# CITY OF ALBUQUERQUE

January 28, 2026

**RE: 99999 86<sup>th</sup> St SW**  
**Grading and Drainage Plan**  
**Engineer's Stamp Date: Missing**  
**Hydrology File: L10D032**  
**Case # HYDR-2026-00006**

Based upon the information provided in your submittal 1/9/2025, the Grading and Drainage Plan **is not approved** for Grading Permit and Building Permit. The following comments need to be addressed for approval of the above referenced project.

DRAWN BY: RMG
 DATE: 01-09-2025
 DRAWING: 2022028_GRB
 SHEET #: **GR-1**
 JOB #: 2022028

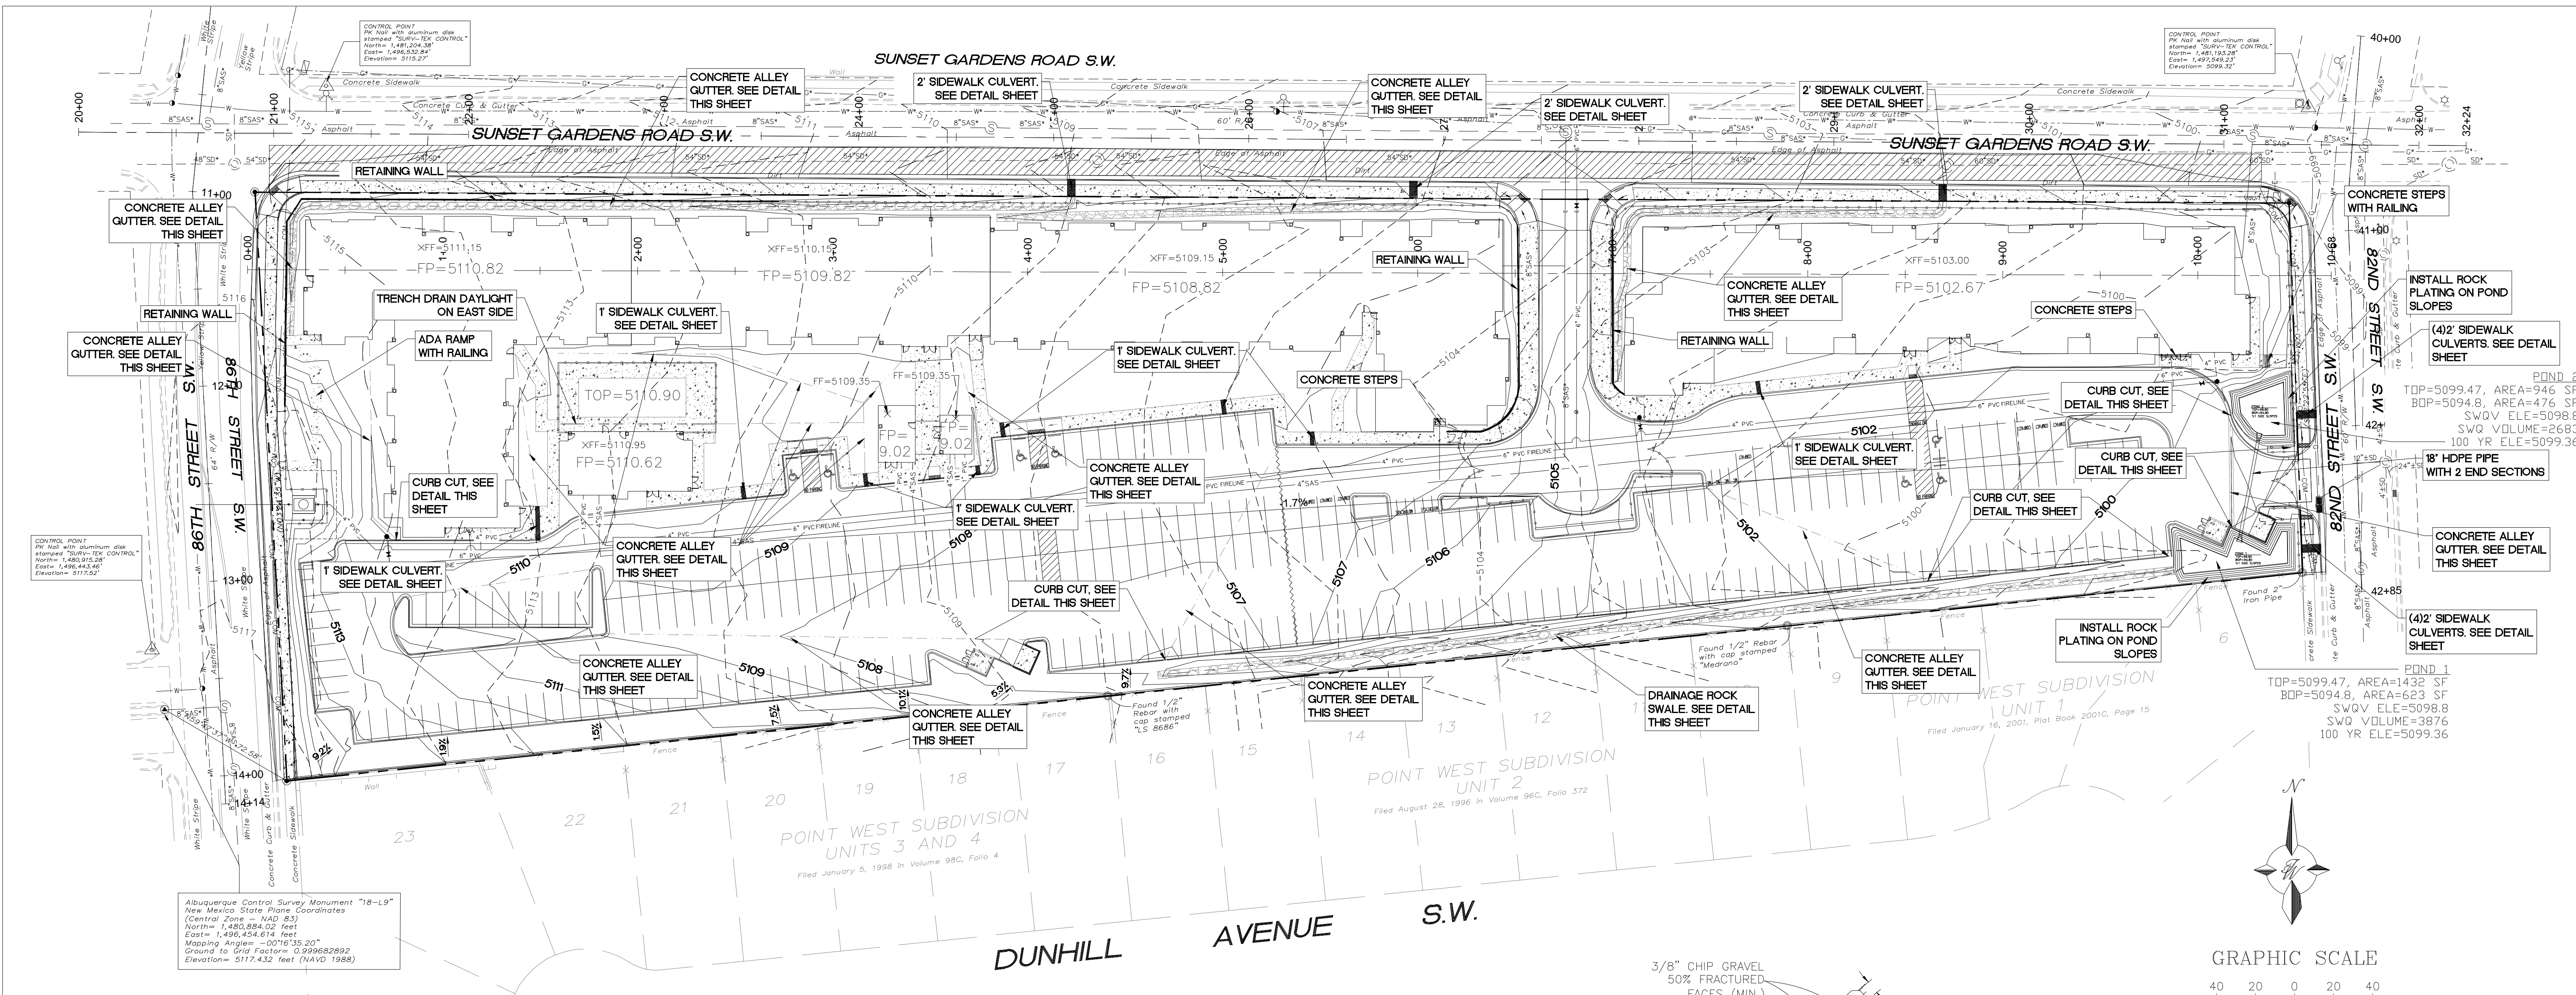
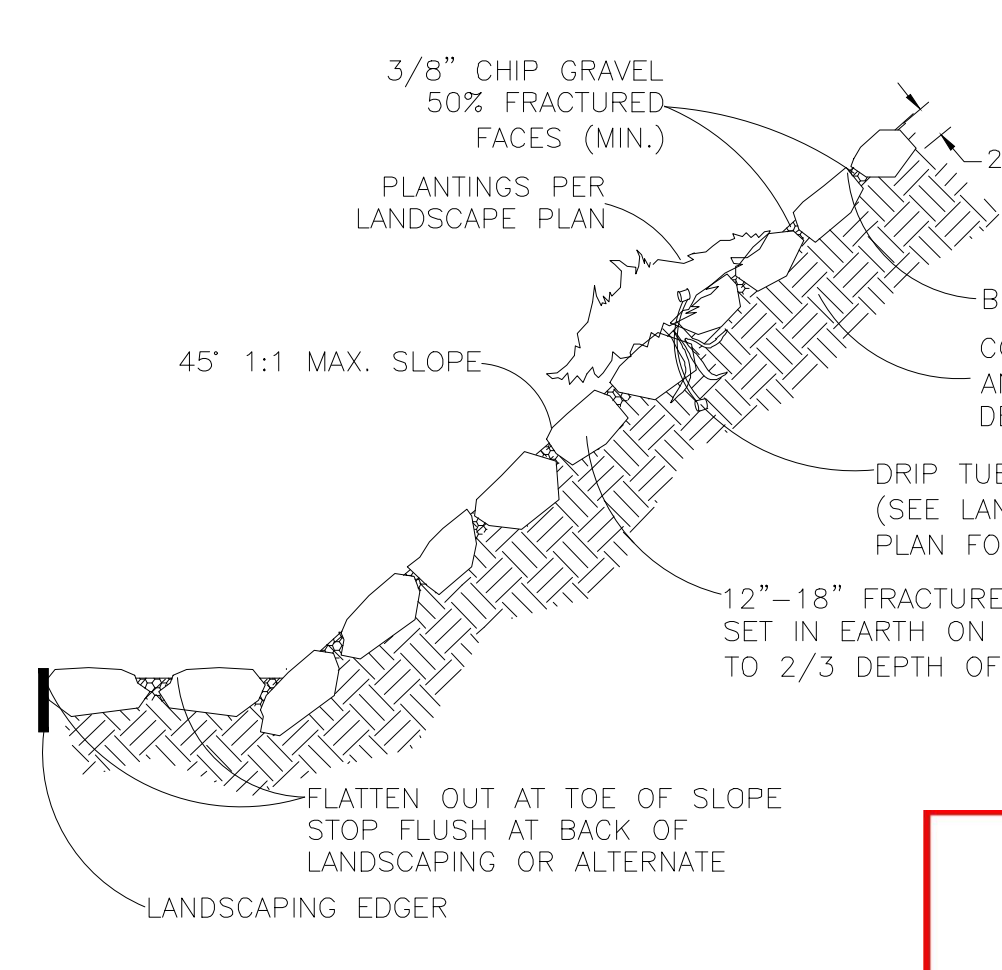
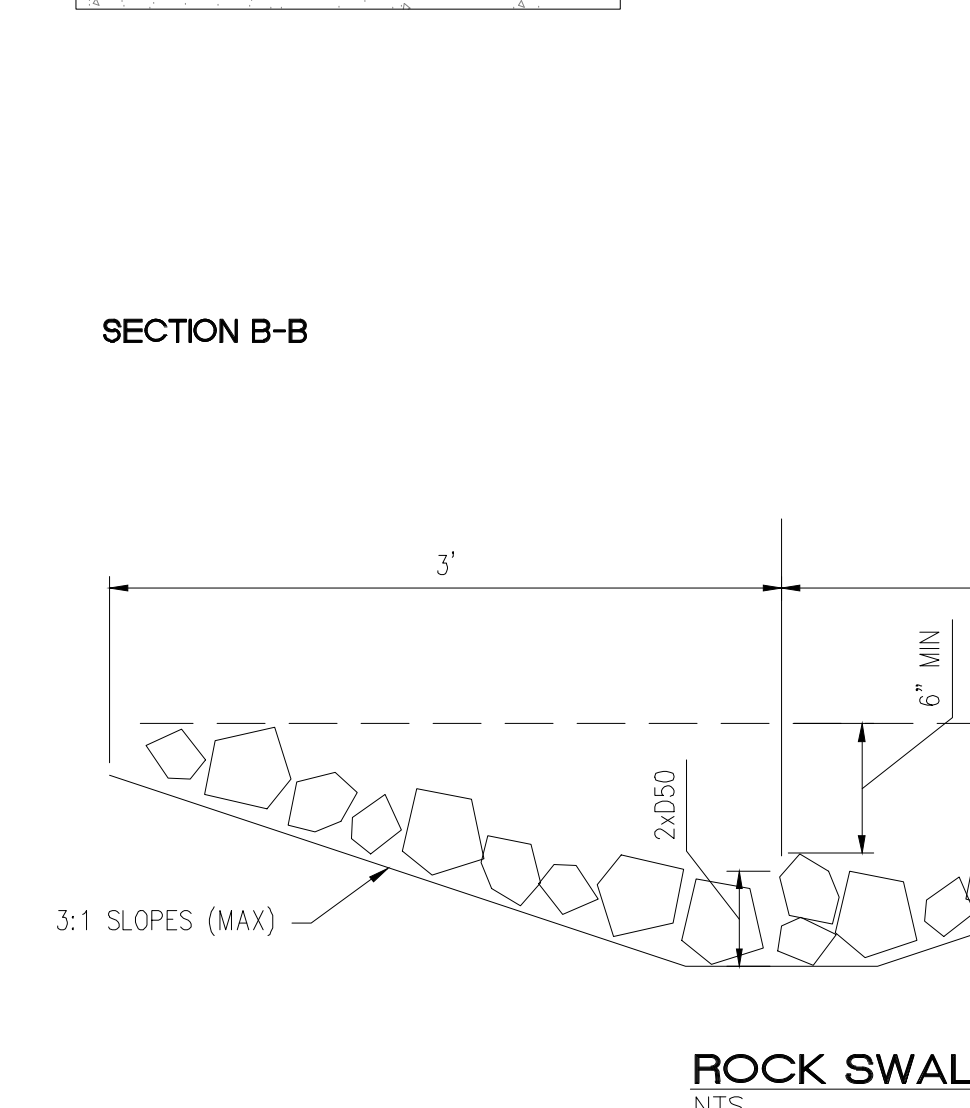
2. Per DPM Article 6-4 Grading and Erosion Criteria, Part 6-4(A) Slope Criteria, maximum slope should not exceed 2:1 (horizontal to vertical) for slopes 3.0 feet high or less. Side slopes are shown as 1:1 currently. Please fix to fulfil the slope requirements while maintaining sufficient pond volume.
3. Please update the Grading Notes under 'Erosion Control Notes' to reflect City of Albuquerque policy, not City of Rio Rancho. Note should state: "Side slopes need to be stabilized with Native Grass Seed (per City Spec 1012) with Aggregate Mulch or equal (Must satisfy the "Final Stabilization criteria" CGP 2.2.14.b.)".

4. Please provide the FIRM Map and floodplain note **with effective date**.

5. Please number the ponds and include a label on each with the SWQV and elevation, the 100-year volume and elevation, the peak 100-year inflow and outflow, the spillway crest elevation, the spillway flow depth, and the dam top elevation.
6. Please show finished pad (FP) elevation and Finished Floor (FF) elevation. Should not be the same value.

7. What is going to happen to the water on the southwest side of the property? Please demonstrate on the plans how water will enter the rock swale and not cross over the property line to the south.
8. Indicate on the plans where the roof drains will drain to.
9. Update note to say: "No work shall be performed in the public ROW without an approved Work Order or Excavation Permit."
